Historic England

**APPLICATION BY ANGLIAN WATER SERVICES LIMITED FOR AN ORDER
GRANTING DEVELOPMENT CONSENT FOR THE CAMBRIDGE WASTE-WATER
TREATMENT PLANT RELOCATION PROJECT
APPLICATION REF: WW010003**

**REPRESENTATIONS OF THE HISTORIC BUILDINGS AND MONUMENTS
COMMISSION FOR ENGLAND (HISTORIC ENGLAND)**

Photomontage 1: Year 15 in operation (planar projection, field of view 39.6 degrees x 18 degrees, to be viewed at A3)  
Cambridge Waste Water Treatment Relocation Project: Photomontages

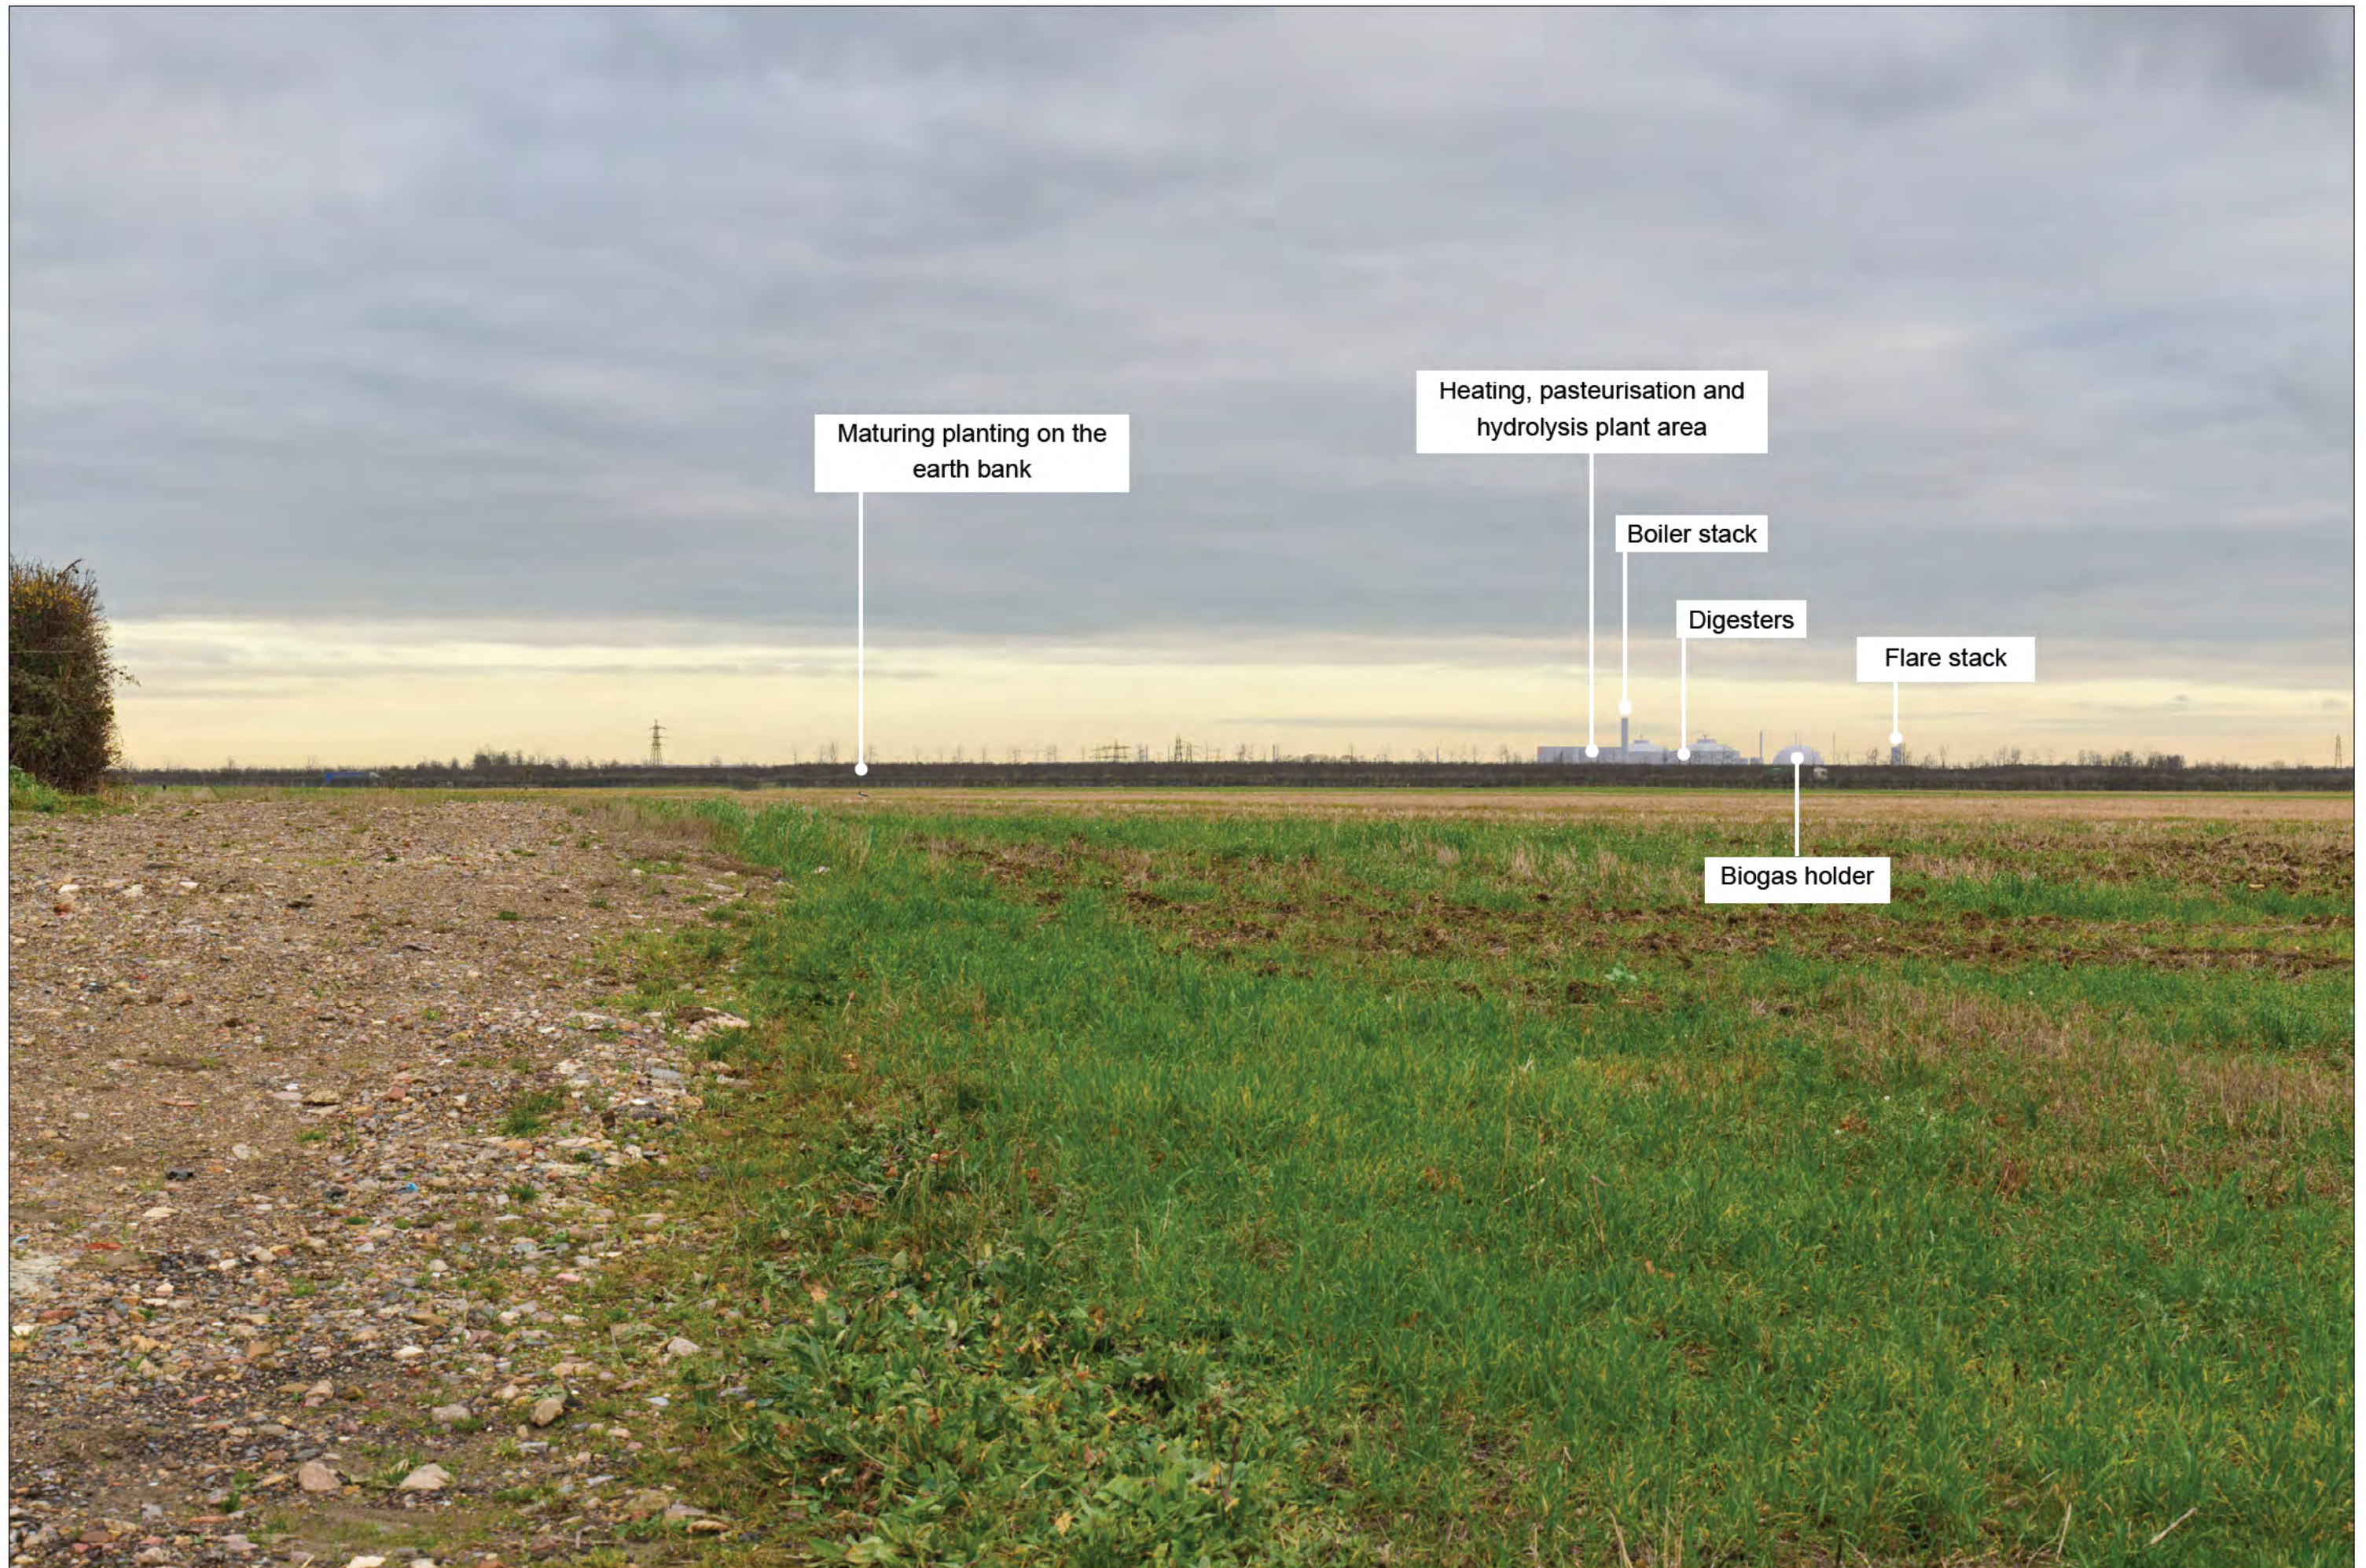
- 2.17. The presence of the proposed facility, which includes various structures of significant scale will result in a fundamental change to the setting of those heritage assets that we have identified. We believe that the facility would therefore be apparent in views from both Bait's Bite (easterly views) and Fen Ditton Conservation Areas (northerly views from High Ditch Road); as well as in easterly views towards the site that take in Biggin Abbey – as demonstrated in the submitted photomontages -particularly images 1 and 2.

## Photomontage 2: View east from Biggin Abbey

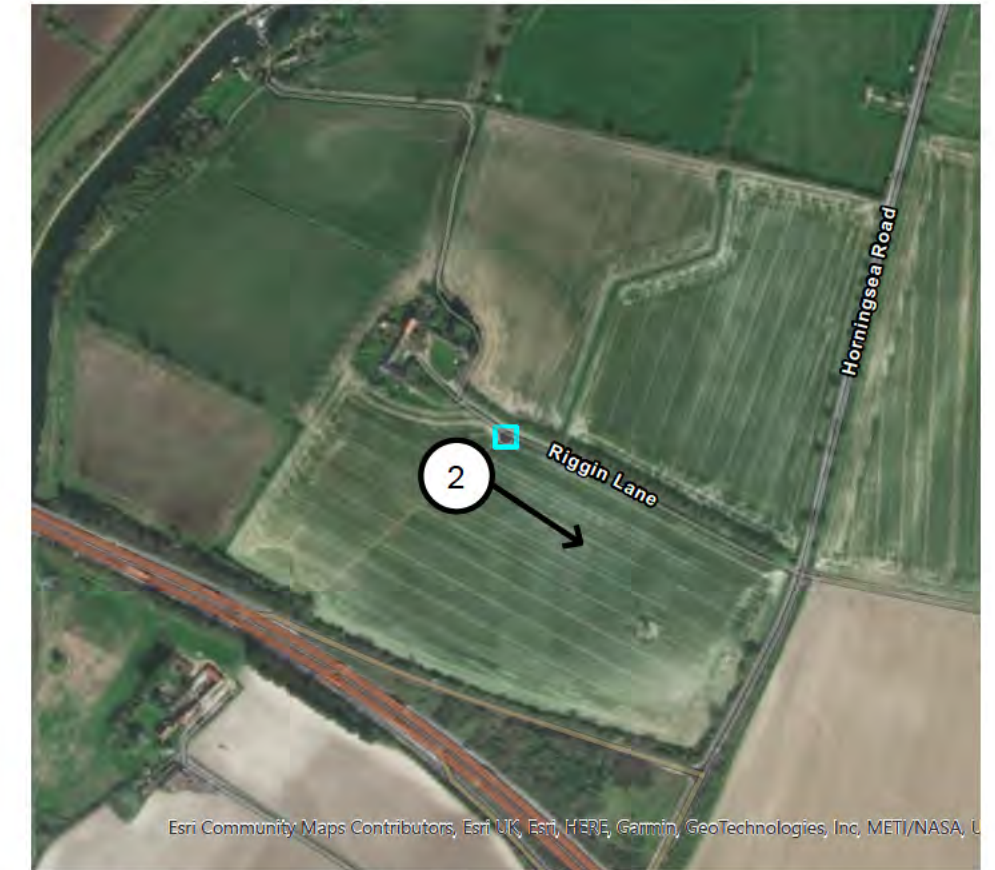
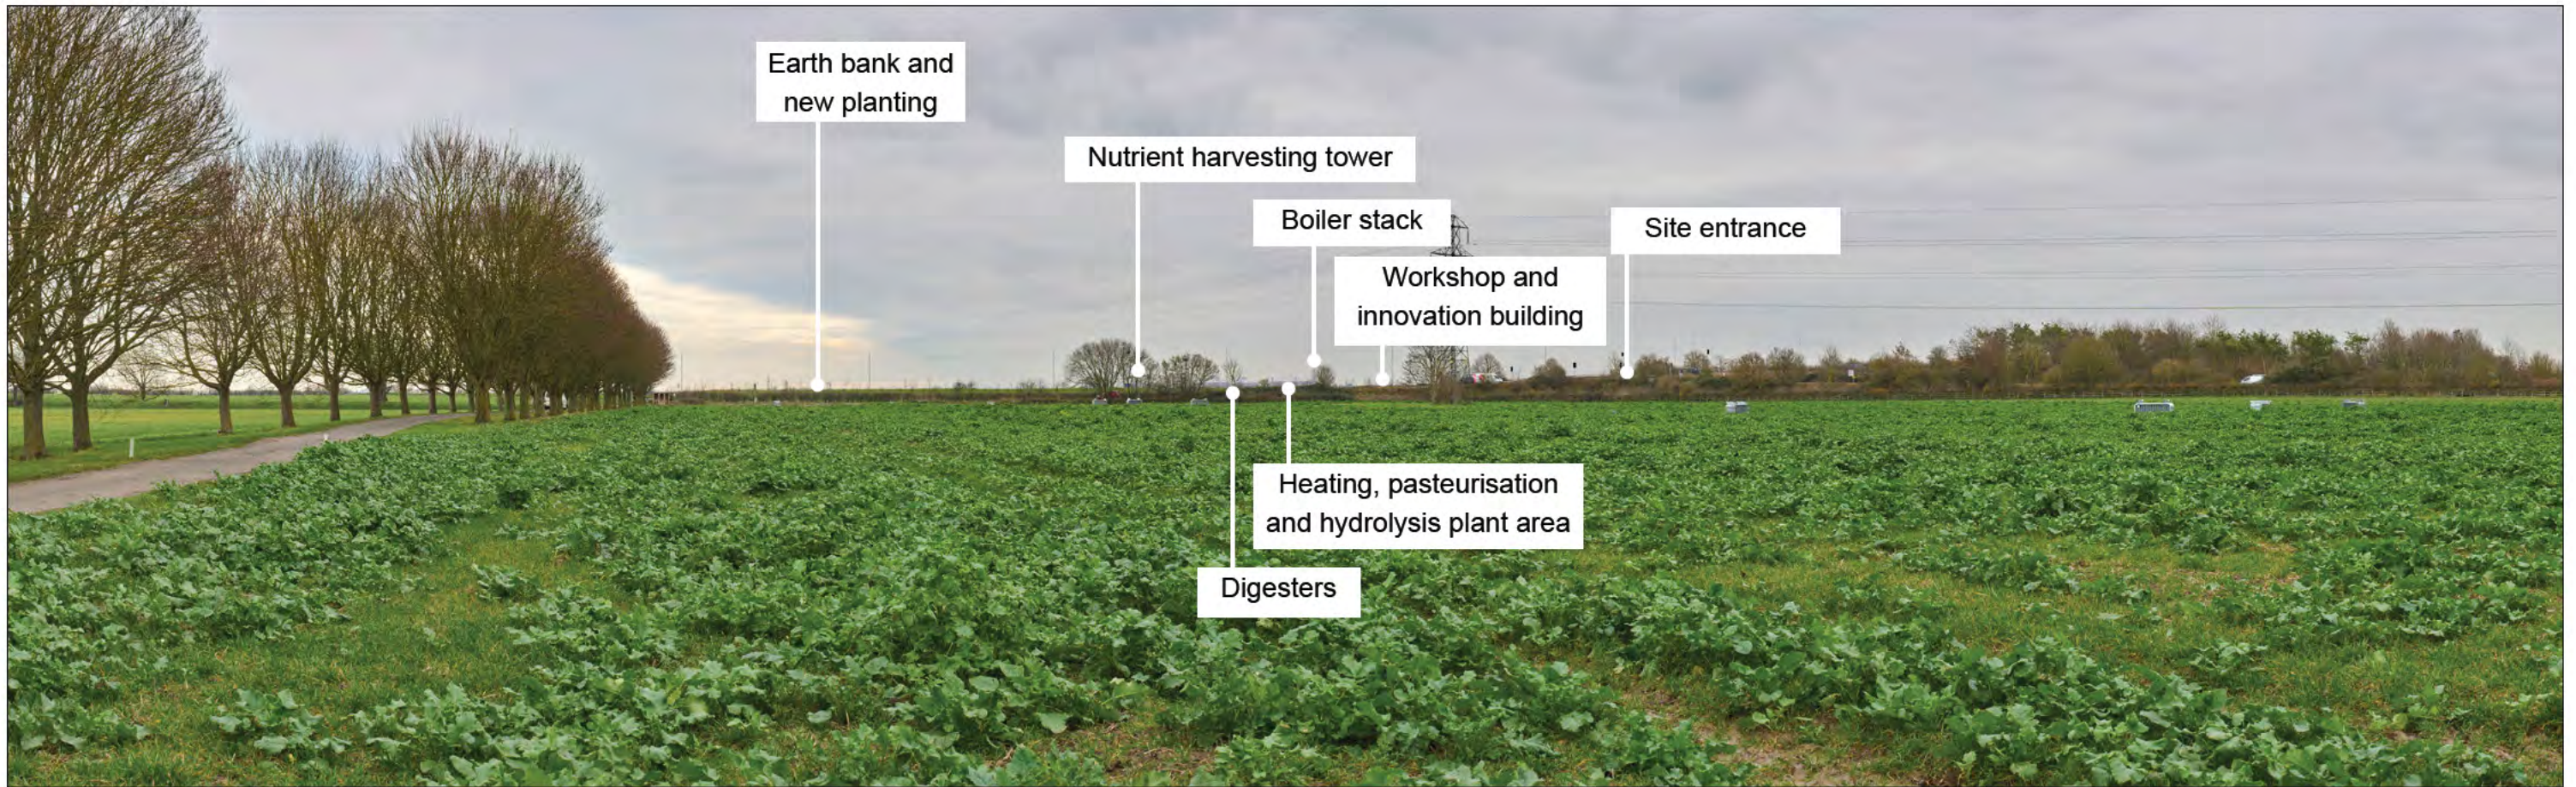
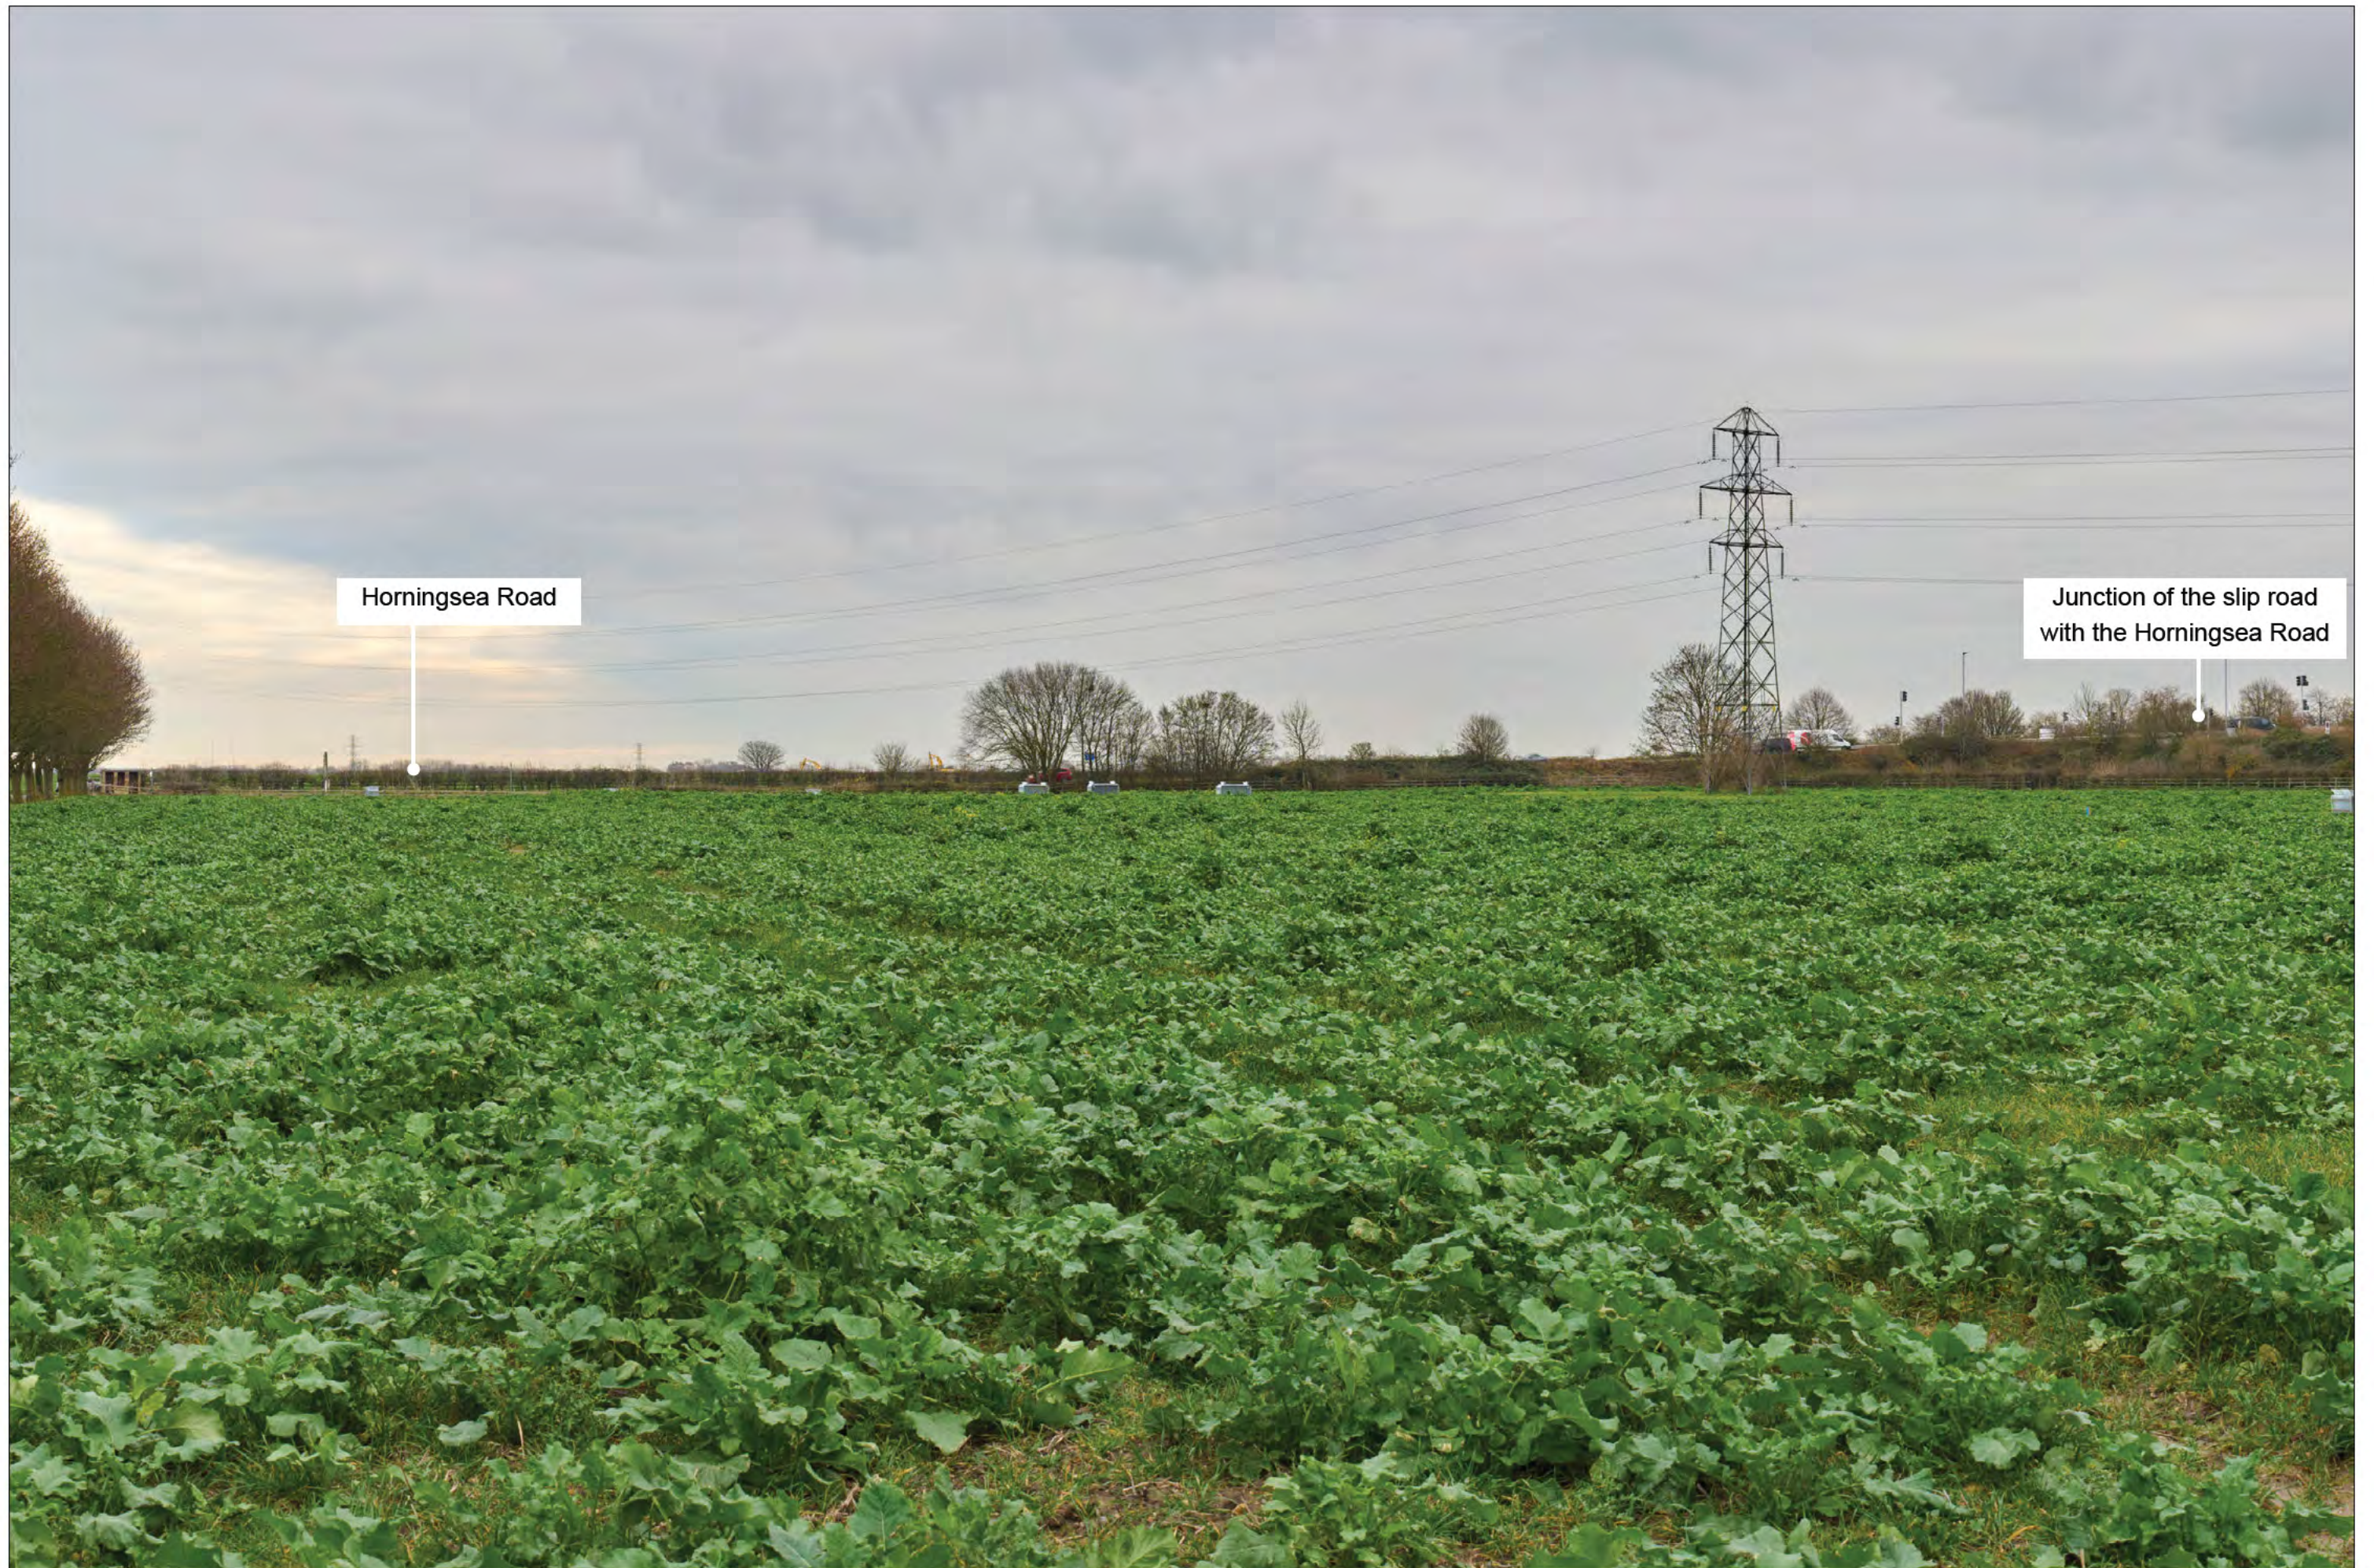
with the flat, open fields that typifies the fenland landscape, that this would have an unfortunate effect in terms of interruption of certain long views – in particular easterly views from Biggin Abbey and its immediate environs (photomontage 2).
